**Narrabri Gas Project (6456)
Supplementary Response to Submissions**

The Department of Planning Industry & Environment: Water Group has reviewed the supplementary information provided by Santos. We advise that Santos has not sufficiently addressed issues raised in earlier correspondence dated 29 April 2017 and 9 October 2018. These concerns continue to be:

Detailed advice to DPIE Planning & Assessment about the Santos Supplementary RTS.

Figure 3-5 Monitoring locations for streamflow

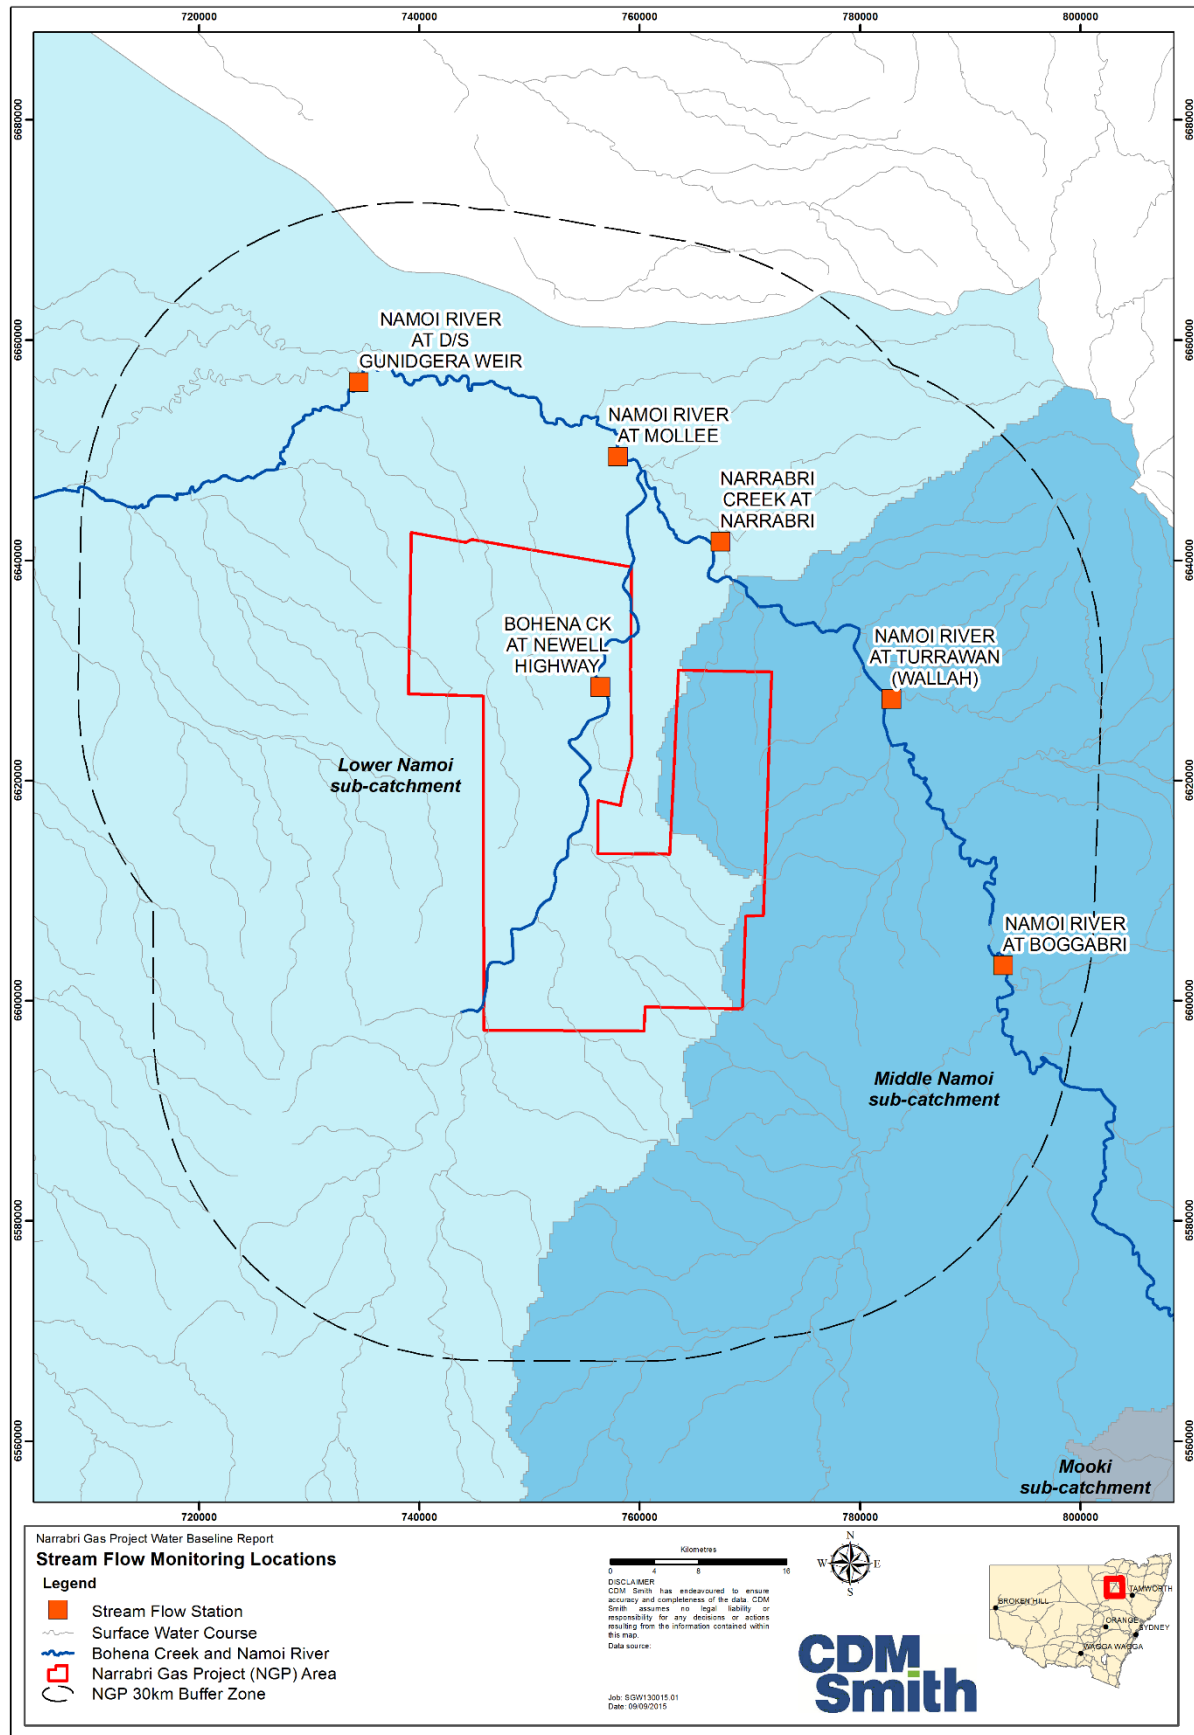
The Bohena gauging station is no longer in use. Santos will need to assess locations suitable along the creek profile and establish a new station closer to the discharge point.
